**Re: Take 5 Oil Change at 1105 Snow Vista Blvd SW
Erosion and Sediment Control Plan
Engineer's Stamp Date 9/19/2023 (M09E012C)**

Based upon the information provided in your submittal received on 10/19/23, the above referenced ESC Plan is approved to be included in the SWPPP and Building Permit Plans; however, the NOI documentation was missing, so the ESC Plan cannot be approved for Grading Permit, or Building Permit.

No.	Date	By	Ctd.	Appr.	Revision
Title: EROSION AND SEDIMENT CONTROL PLAN 1105 SNOW VISTA BOULEVARD SW ALBUQUERQUE, NM

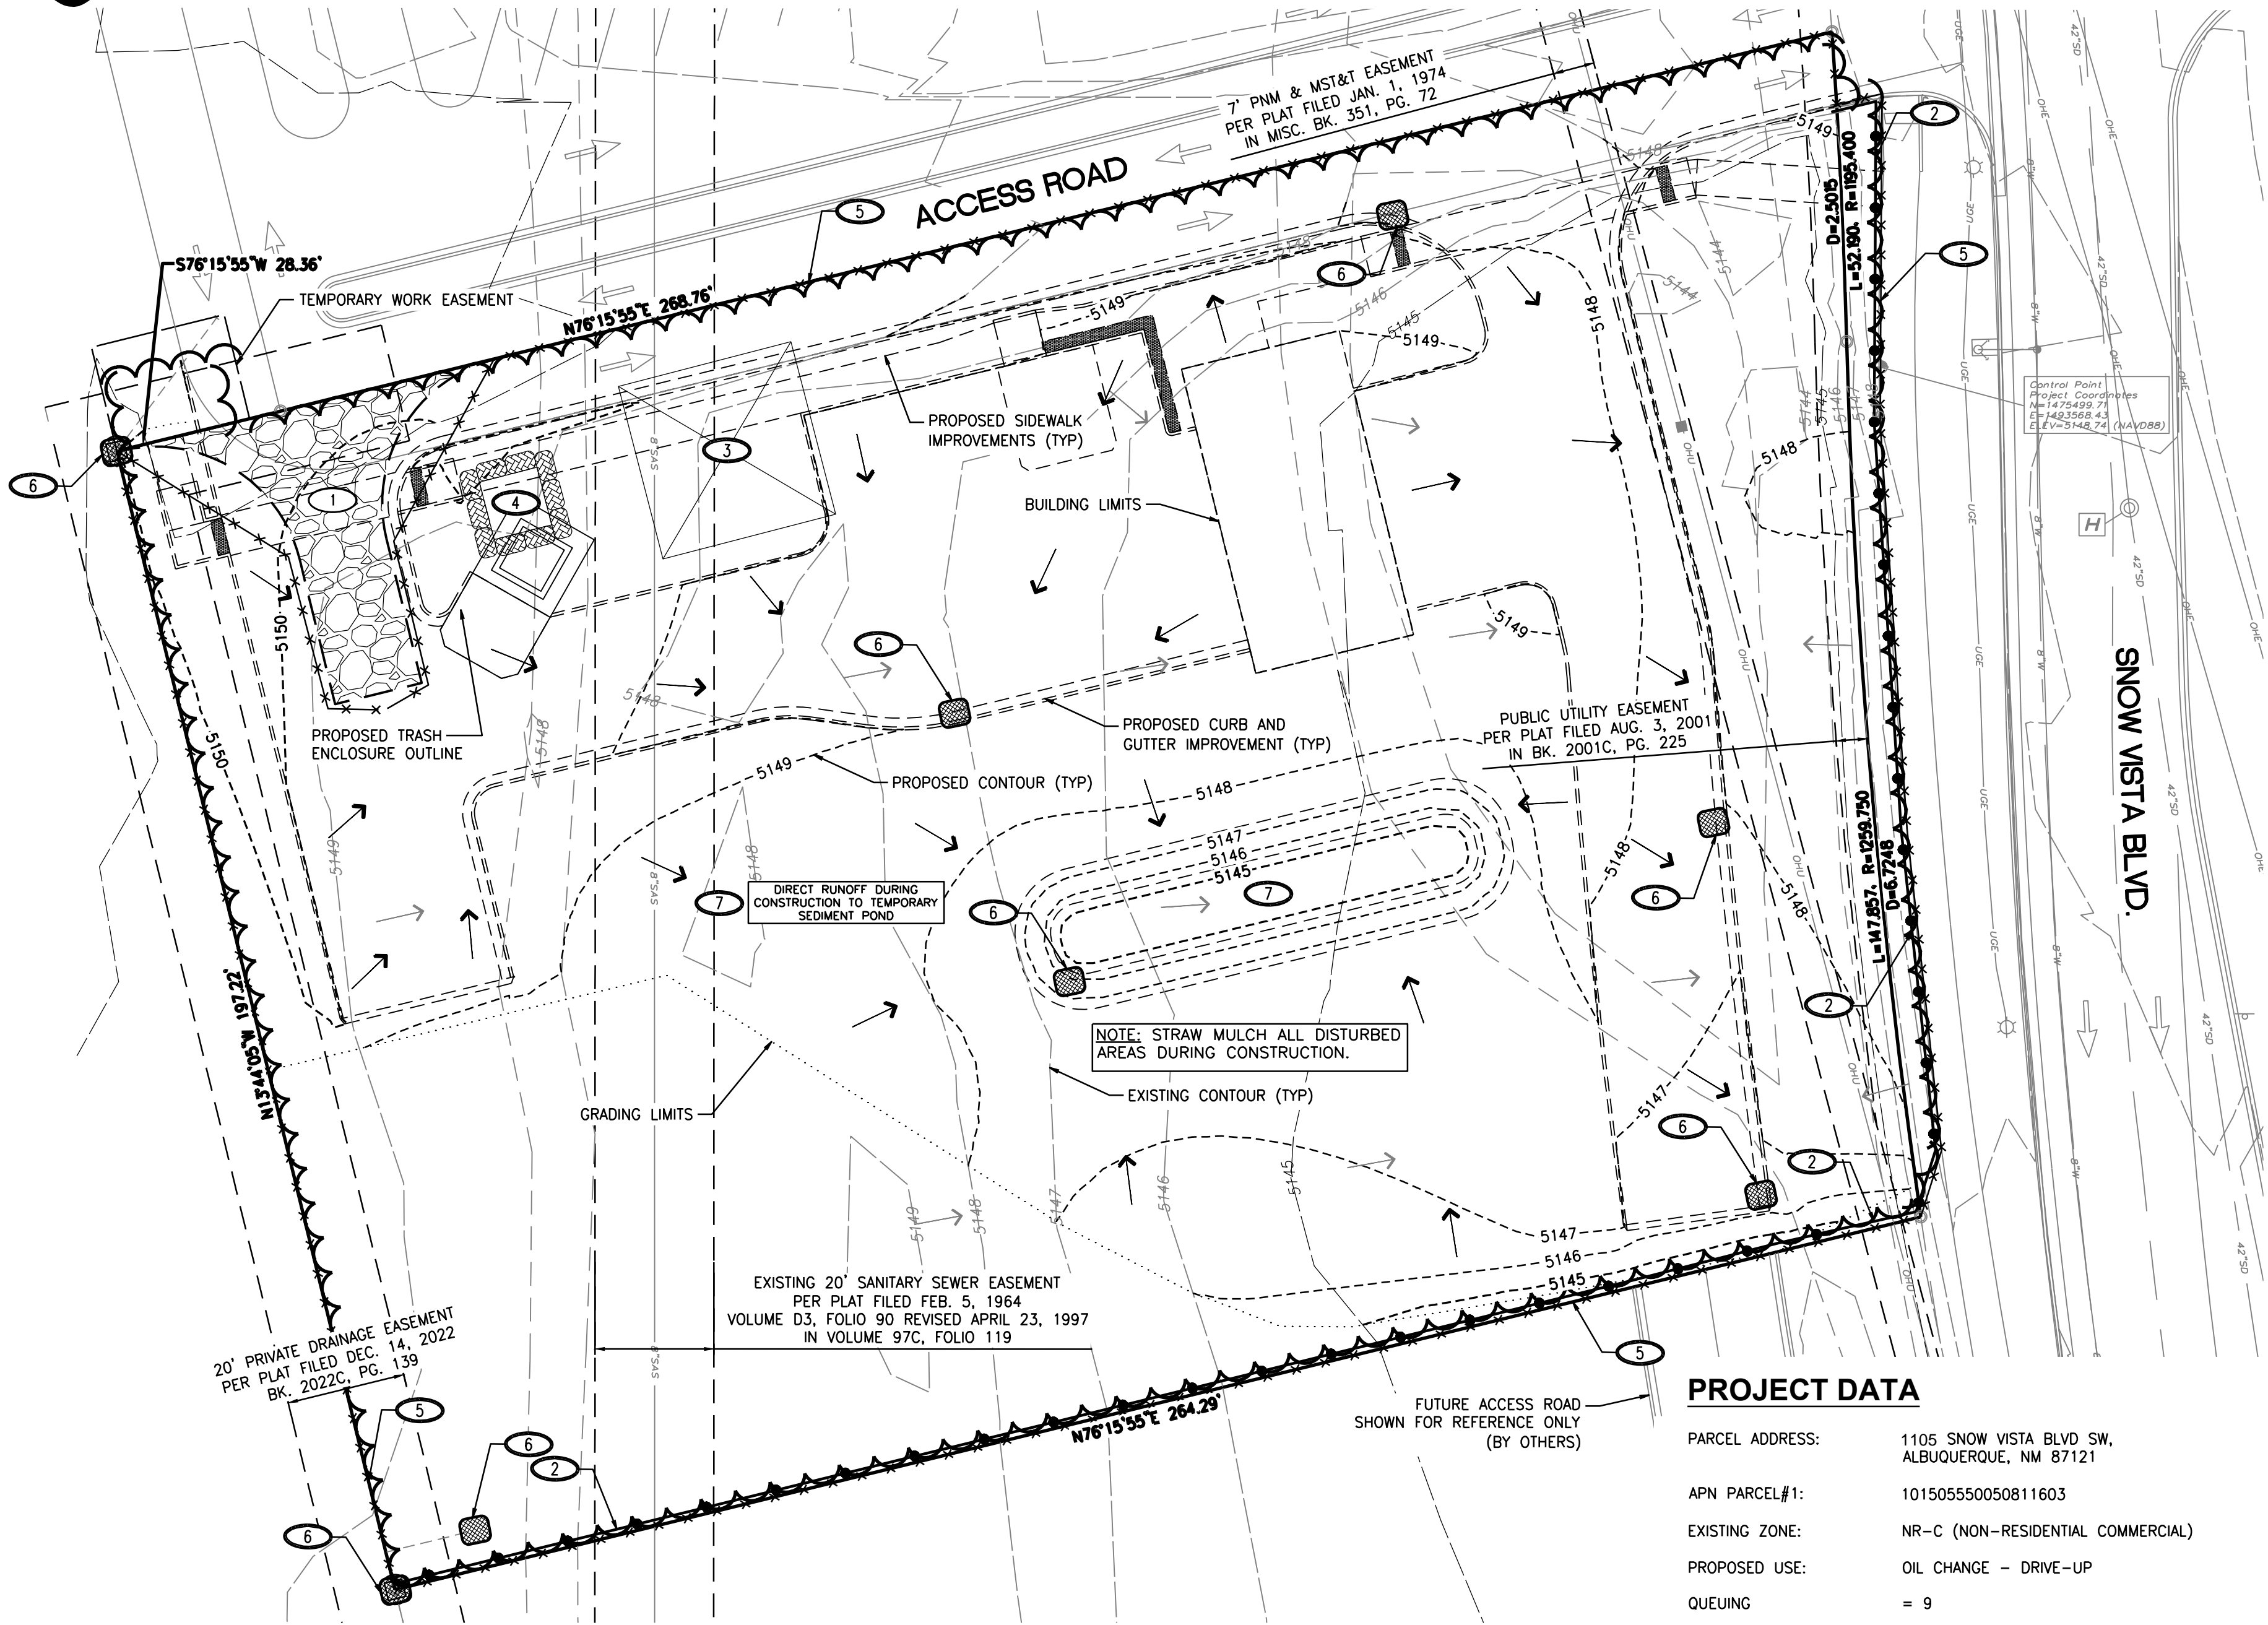
5. Note on the ESC "This site is part of a *Common Plan of Development or Sale* that exceeds 5 acres. Every part of this *Common Plan of Development or Sale* must have coverage under the CGP. Waivers aren't allowed."

Title: EROSION AND SEDIMENT CONTROL PLAN
1125 SNOW VISTA BOULEVARD SW
ALBUQUERQUE, NM

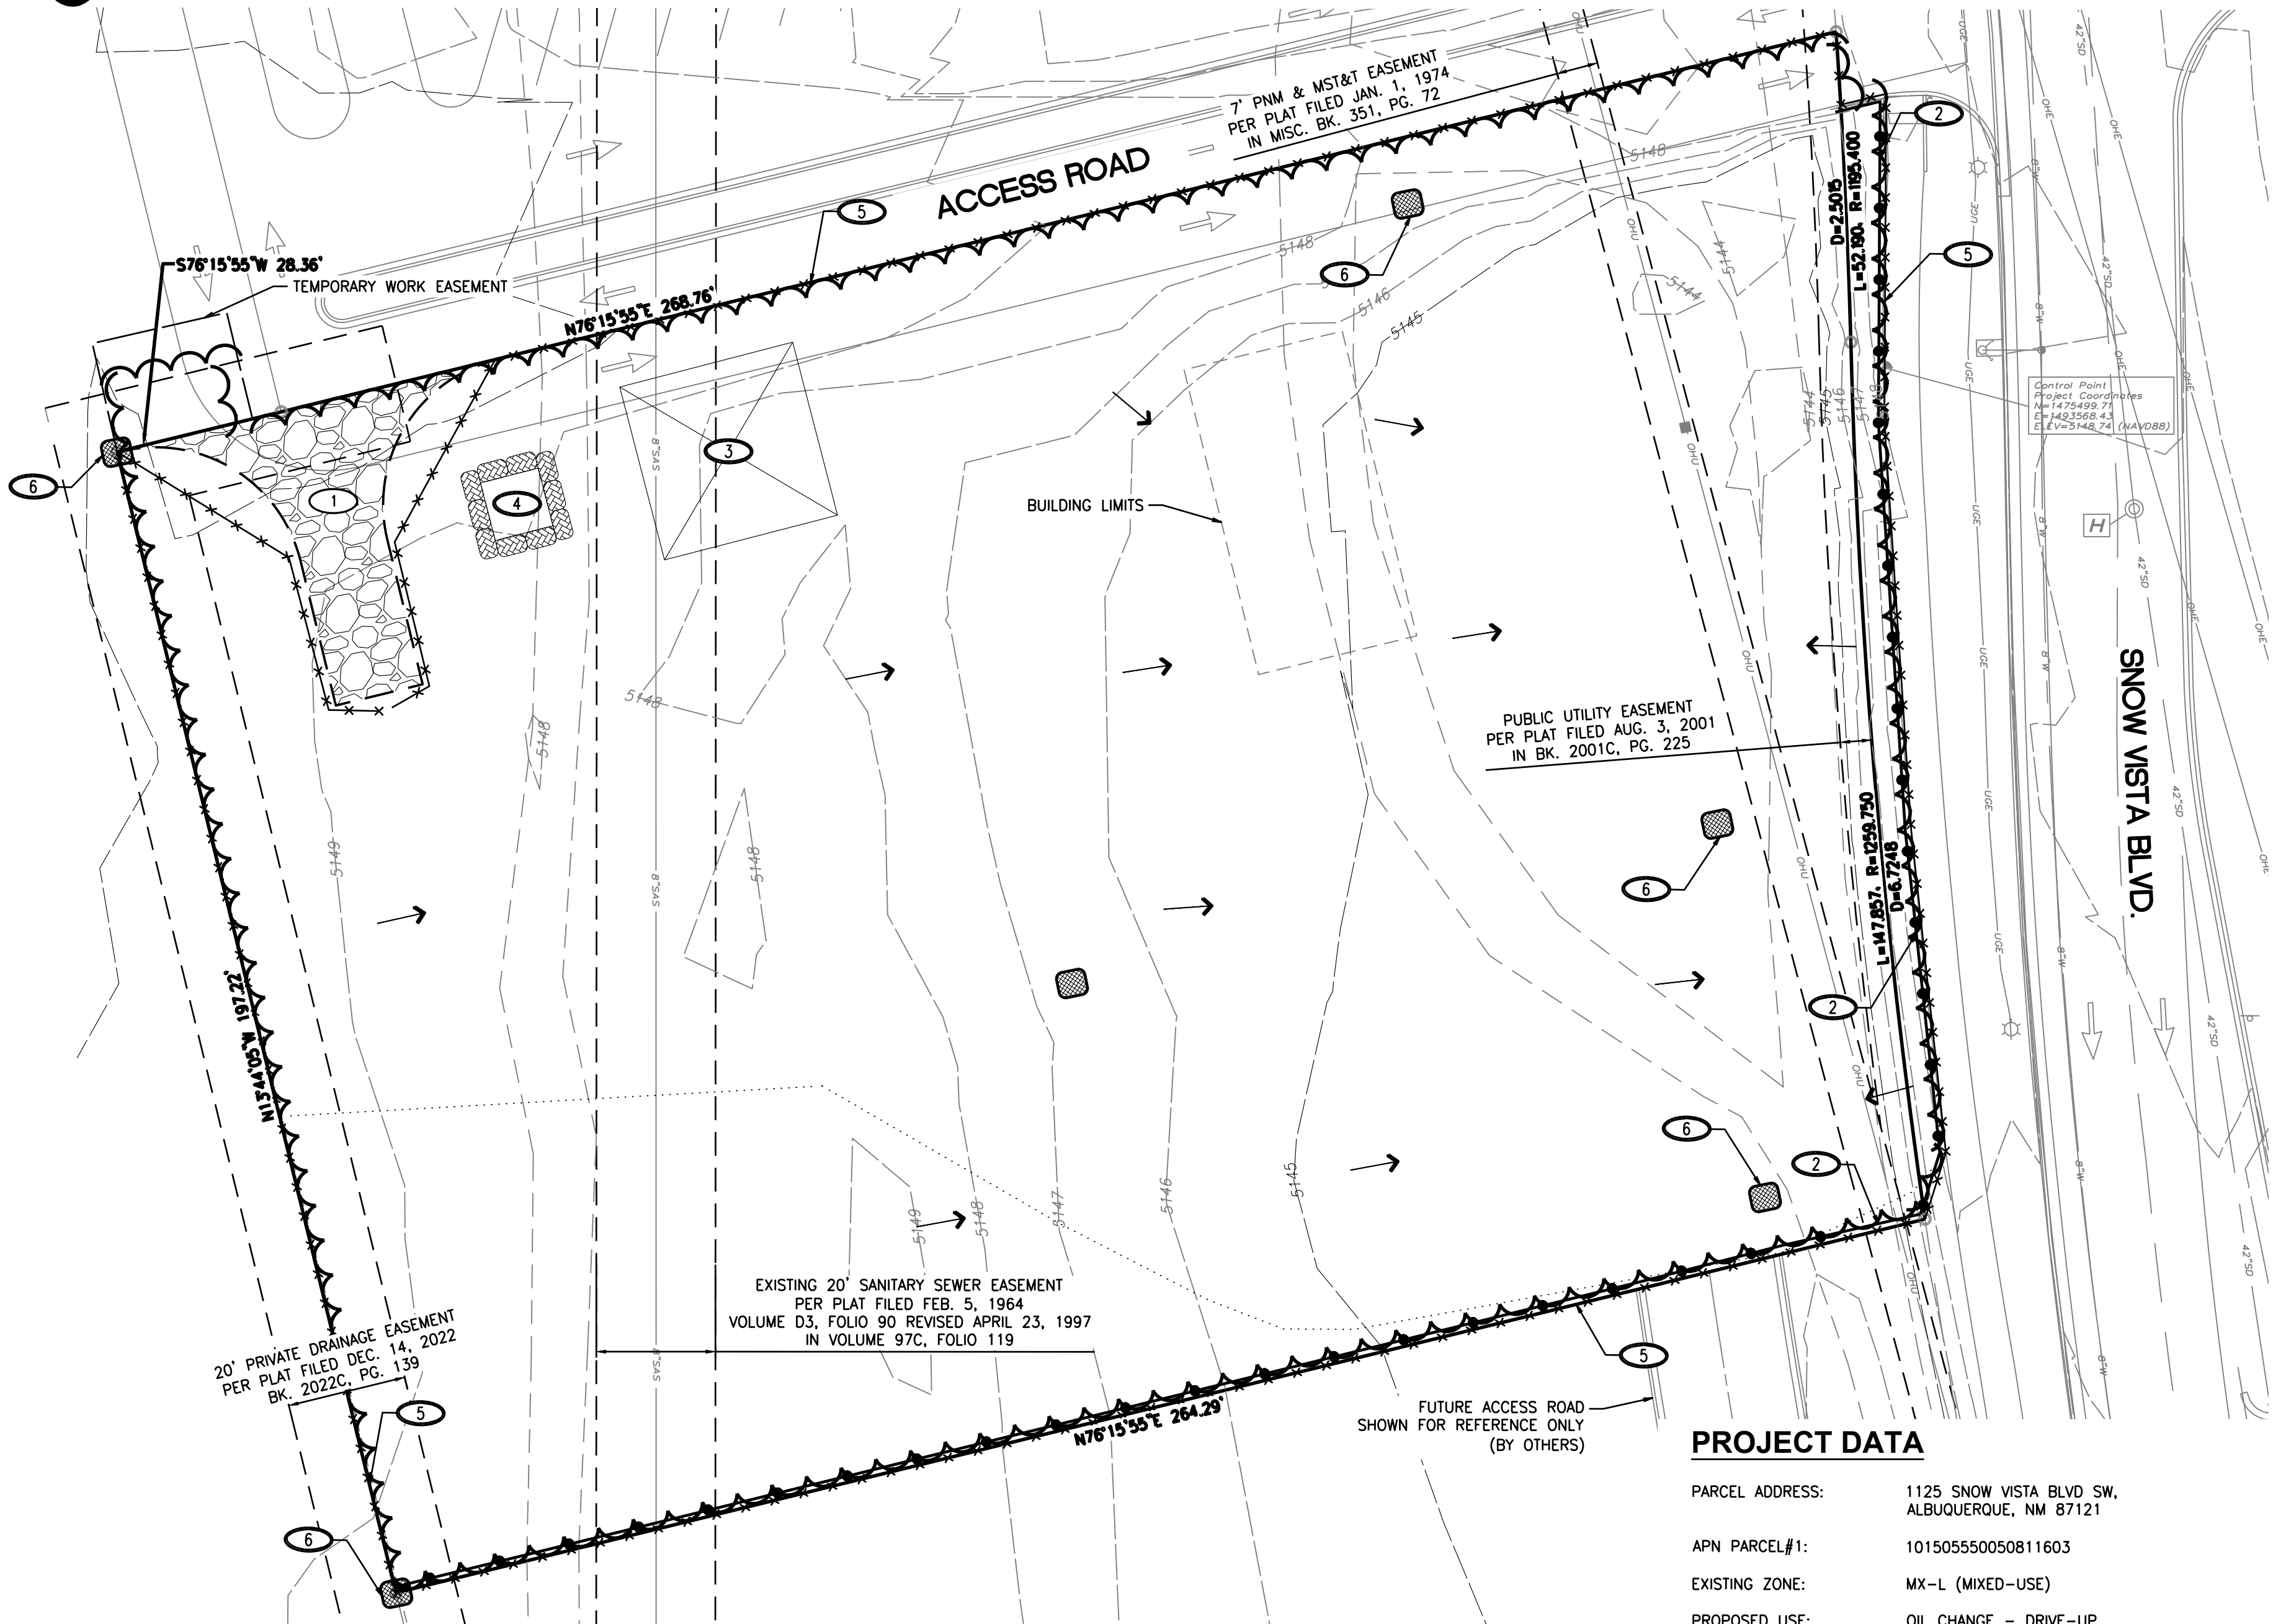
1. The ESC Plan can't be approved until after Hydrology approves the G&D Plan for each specific purpose, Site Plan, Grading, Building Permit, and Work Order. Hydrology's comments on the Conceptual G&D haven't been addressed yet. The existing and proposed grades must be shown on the ESC Plan, and they must agree with the Grading Plan approved by Hydrology (CGP 7.2.4.b.ii);

2. Identify locations of concentrated flow paths that enter and exit the disturbed areas. Identify locations where sheet flow enters and exits the disturbed area. Show on-site drainage patterns of stormwater before and after major grading activities. (CGP 7.2.4.f)

3. The building, sidewalk, asphalt, and dirt must be shown on the ESC Plan. These structures must be clearly identified in the SWPPP per CGP 7.2.4.b.vi.

4. Describe the nature and extent of construction activities (CGP 7.2.2.). Include the size of the property, and the size of the area of land disturbing activities onsite and offsite. Why is the project area less than the total lot area? Describe construction support activities and show any staging area on the ESC Plan.

6. The SWPPP must include site-specific interim and permanent stabilization per CGP 9.4.1.c.i. The Landscape Plan can be used to satisfy this requirement and should be submitted separate from the ESC Plan with the application to the Stormwater Quality Section of the Planning Department and they should be included in the SWPPP. Provide a specification on the ESC Plan for any disturbed areas not covered by the Landscape Plan

7. The owner information shown on the Information Sheet does not agree with the available Bernalillo County records. The accurate name and contact information for the entity in control of the property rights is required and should also be shown on the Information Sheet, the NPDES documentation, and the ESC Plan. Property rights may have changed hands recently, if so, please provide documentation in the form of a recorded deed or lease. The property owner's NOI is required. The individual signing the NOI must satisfy the requirements of CGP G.11.1 and all other documents in the SWPPP must be certified per CGP G.11.2-4.
8. Update the engineer's stamp date each time the plan is changed.
